Your ref: SSD-69799460

Subject: Tilbuster 2 Solar Farm

The Department of Planning, Housing and Infrastructure – Crown Lands has reviewed the Tilbuster 2 Solar Farm EIS. Crown roads are included within the project footprint on this occasion. These are as outlined in the Crown Lands response letter dated 23 July 2024 and shown on the attached map. There have been no further changes to the Crown land outlined in that response, noting that the Crown land includes:

Figure 1.2 shows the indicative layout for the proposal, including the location of solar PV panels, associated infrastructure and internal access roads.

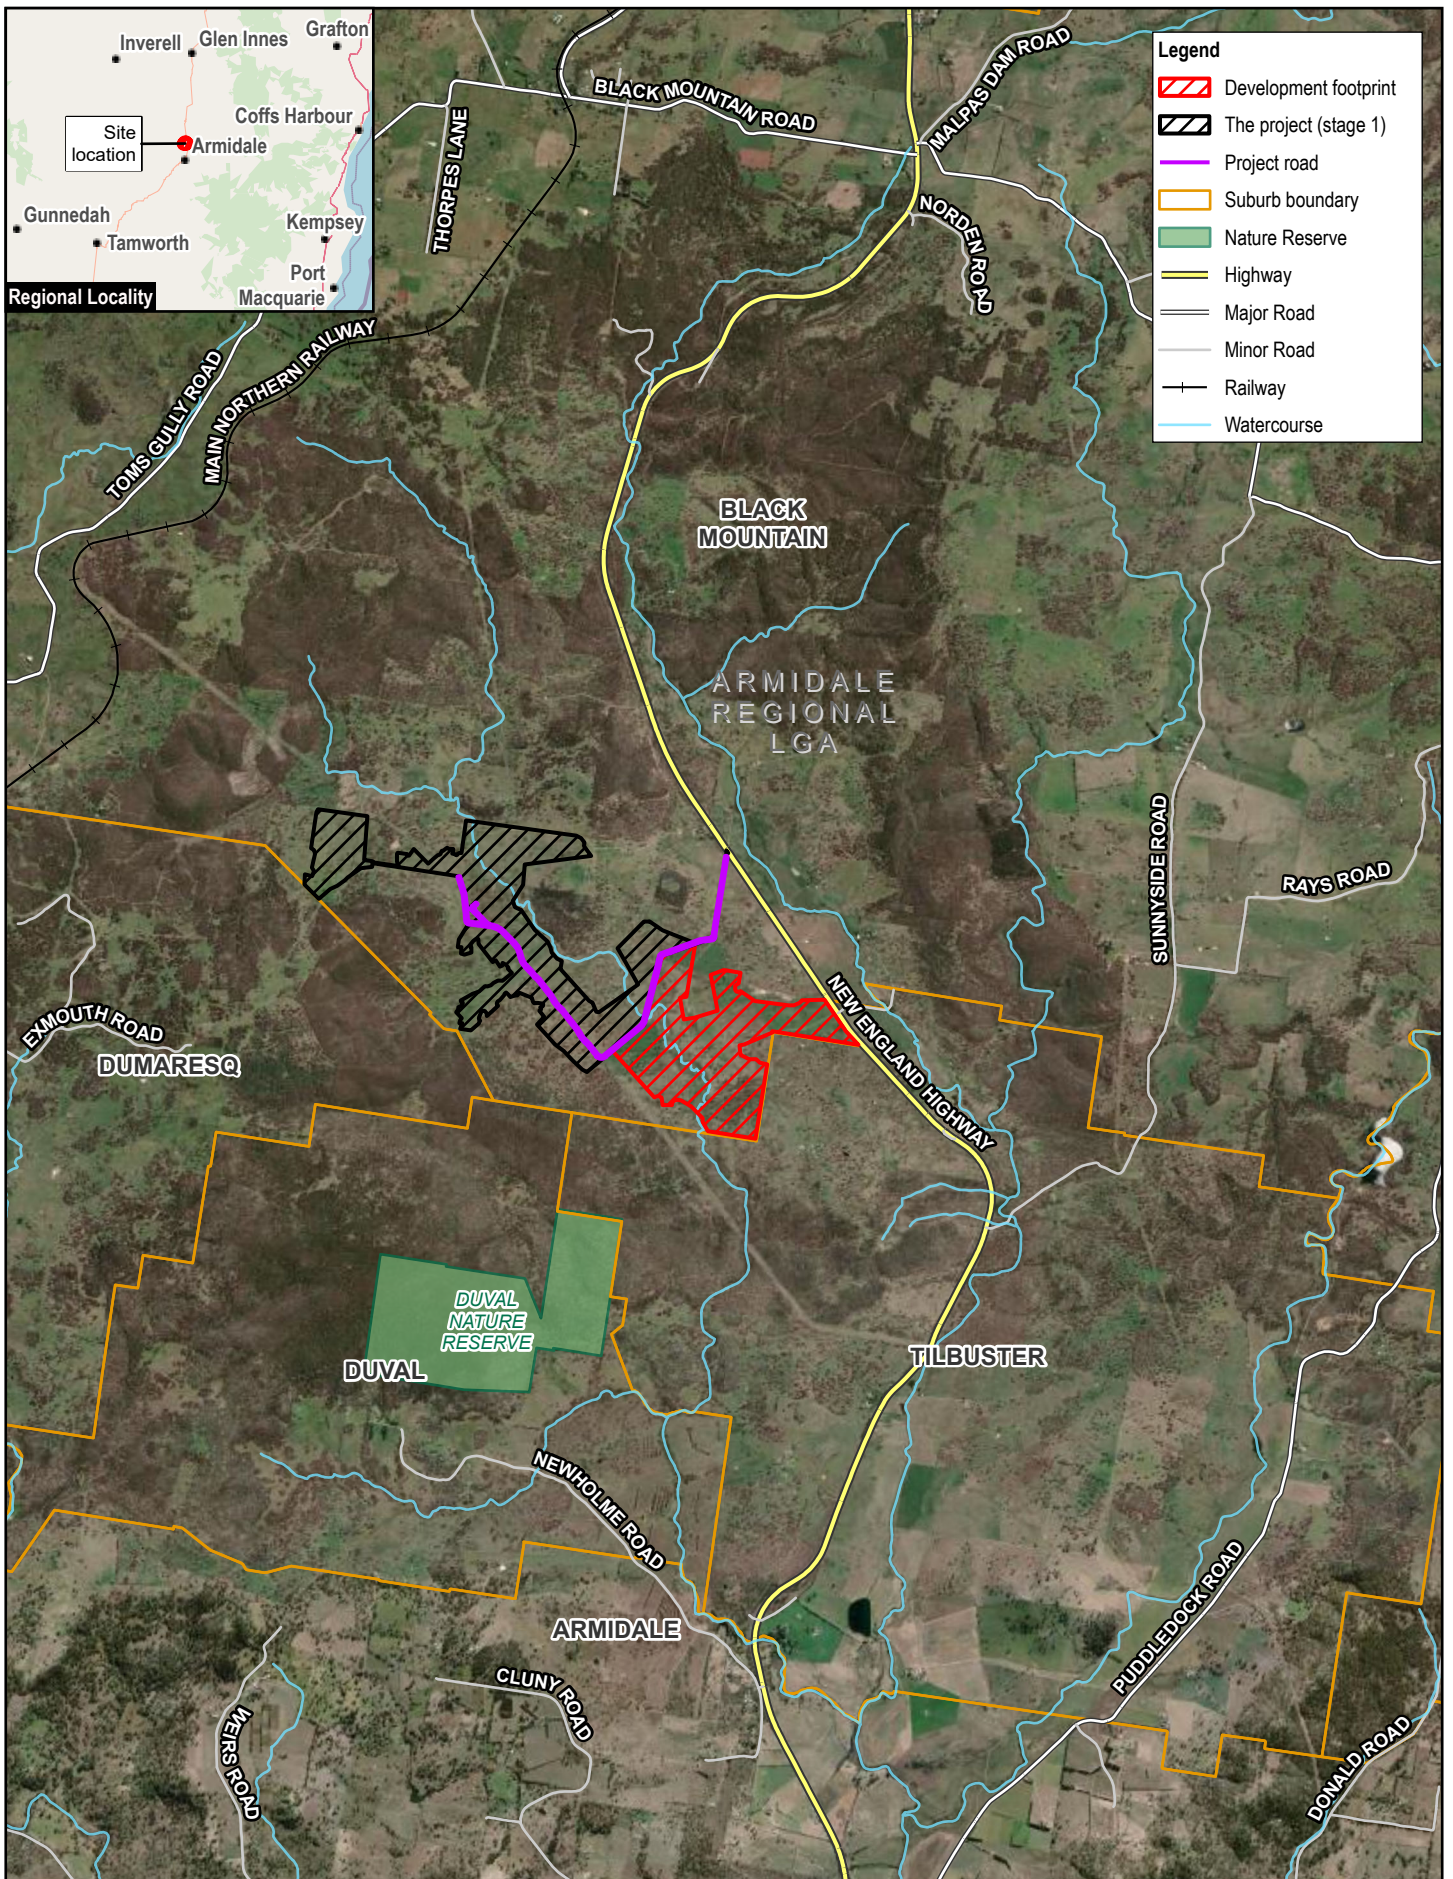
The Crown roads identified will require authority to use, traverse, access, or construct infrastructure under the *Crown Land Management Act 2016* and/or the *Roads Act 1993*. Application to close and purchase the Crown roads is recommended (on behalf of the land owner).
